## TRINITY RANCH

### PRELIMINARY PLAN

TRINITY RANCH  
EL PASO COUNTY, COLORADO  
PRELIMINARY PLAN  
C1.0 - PRELIMINARY PLAN COVER SHEET

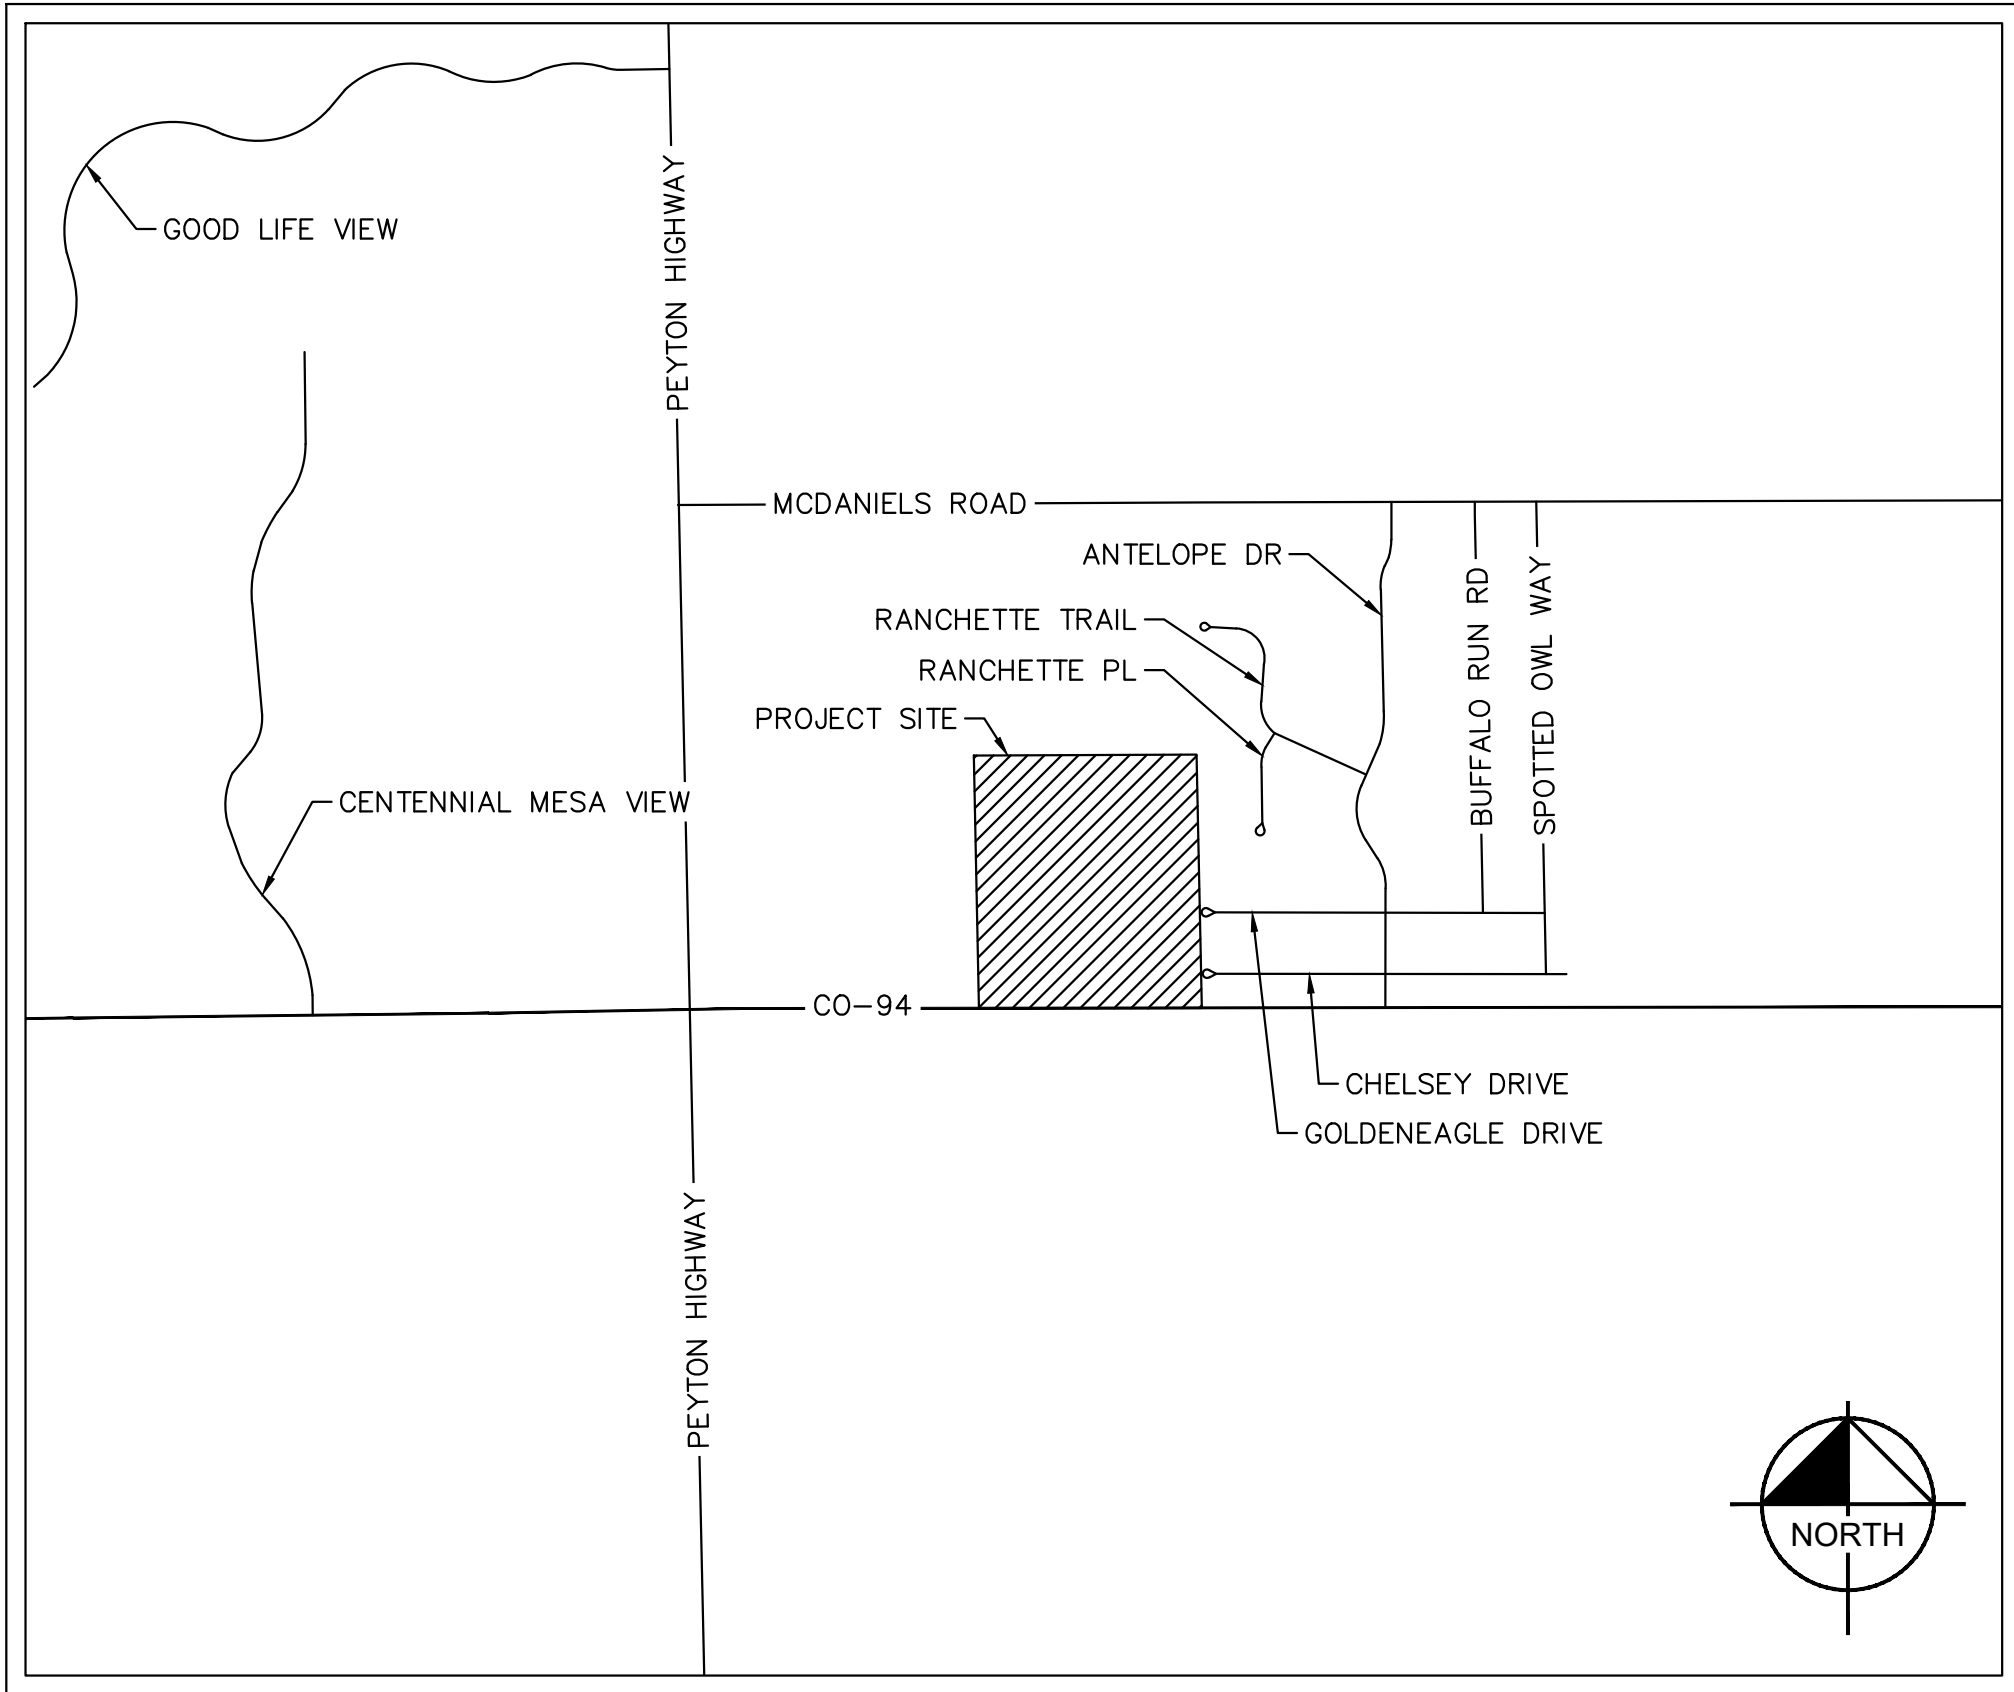
Many of these notes do not meet the standard for El Paso County Preliminary Plan notes. I recommend that you review the Preliminary Plan submittal checklist located on our website and revise the notes accordingly. A full review of the contents of the notes will be provided with the next review.

this acreage is different than all other acreages provided for this project

not the correct acreage

identify which metro district

shouldn't these be the RR-2.5 dimensional standards?

where is tract A? It doesn't appear in any of the plans.

Update to current name

TRINITY RANCH
EL PASO COUNTY, COLORADO
PRELIMINARY PLAN
OVERALL SITE PLAN

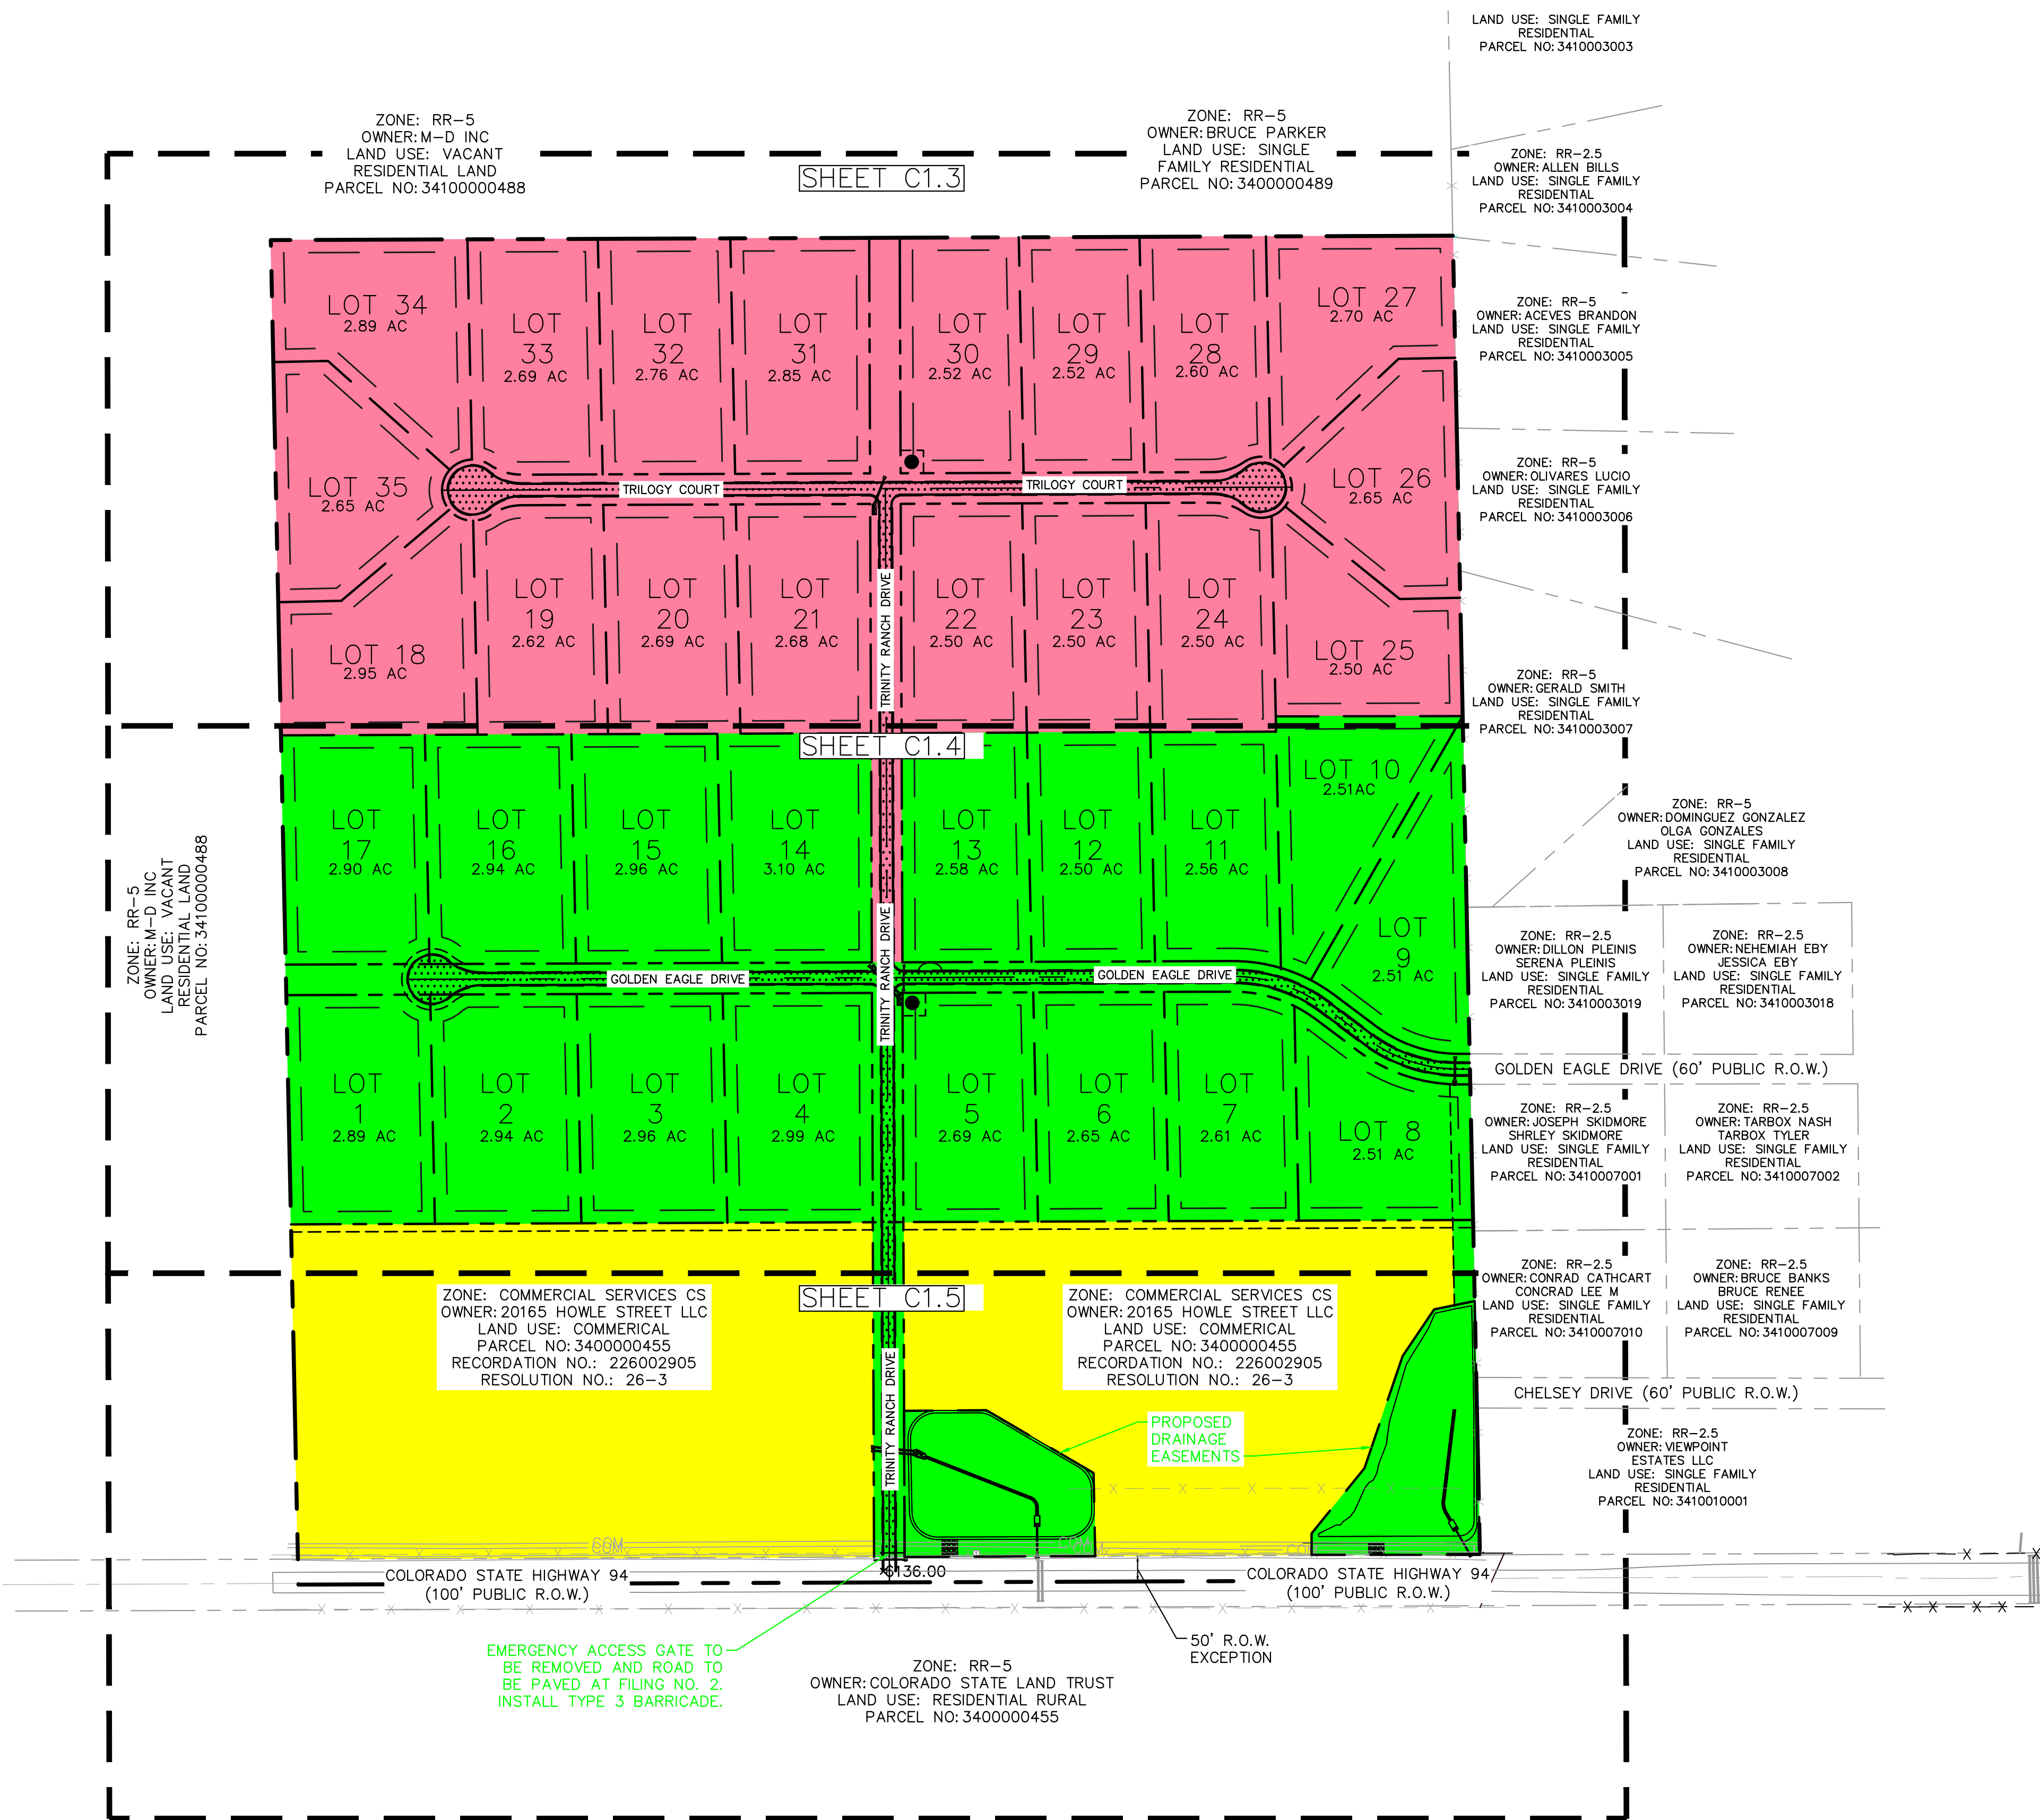
Will the commercial areas be tracts?
